RE: O'Keefe No. 2 Short Plat SP-12-00006

Thank you for the opportunity to comment on the O'Keefe No. 2 Short Plat, SP-12-00006.

O'KEEFE NO. 2 SHORT PLAT

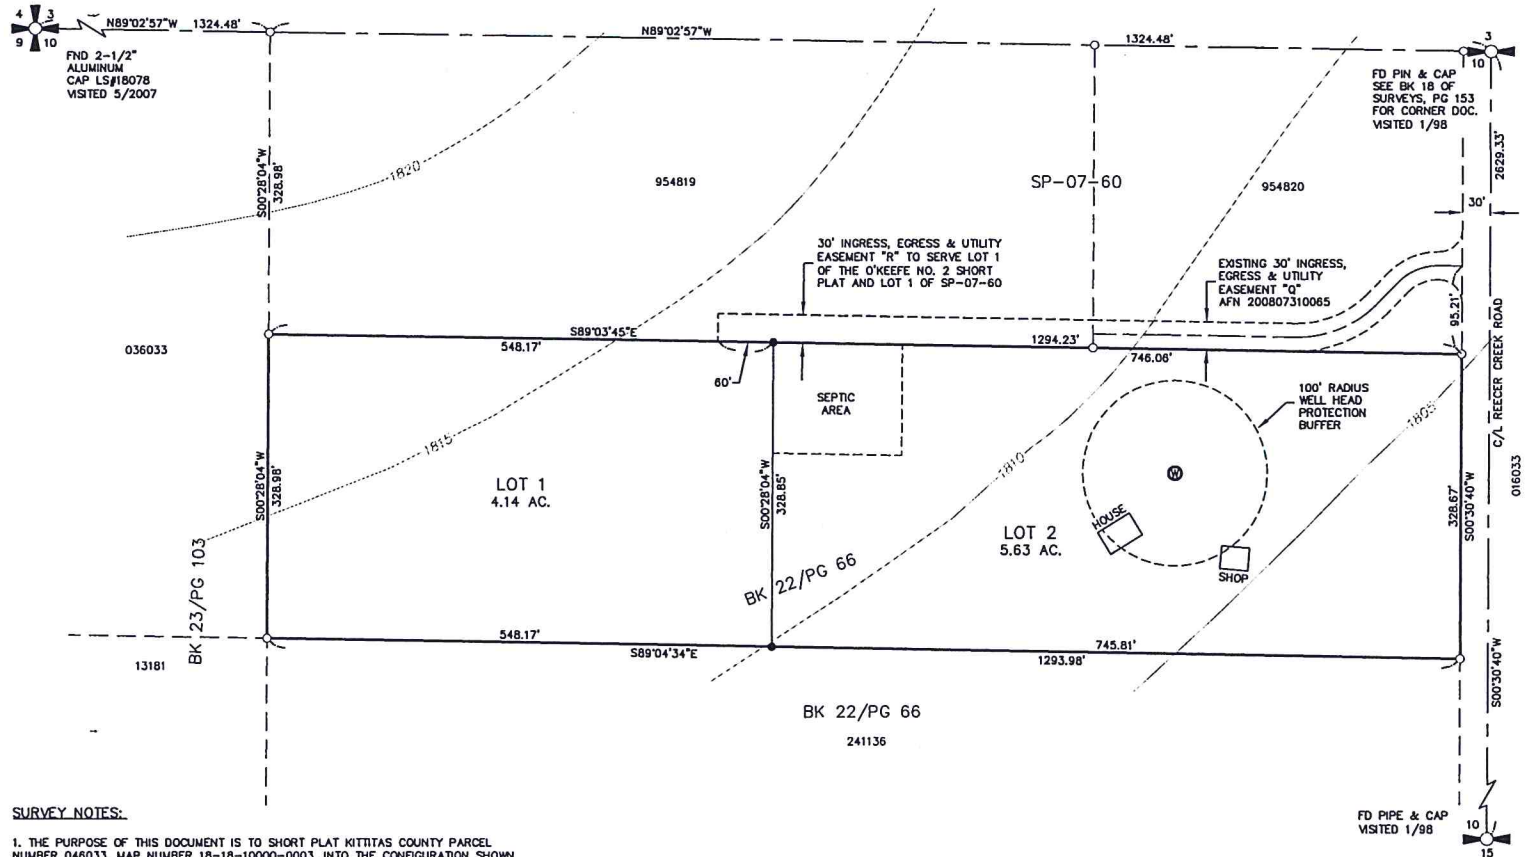
The existing septic system must be at least 10 feet from the proposed property line or a qualifying recorded easement must be recorded on the title of both properties.

At this point in time this application does not contain sufficient information to make a determination that there is an adequate potable water supply available and soil logs have not been conducted to verify soil conditions for on-site sewage systems. The above mentioned requirements need to be satisfied and the appropriate documentation needs to be submitted to KCPHD for review and approval in order for the plat application to be recommended for final approval.
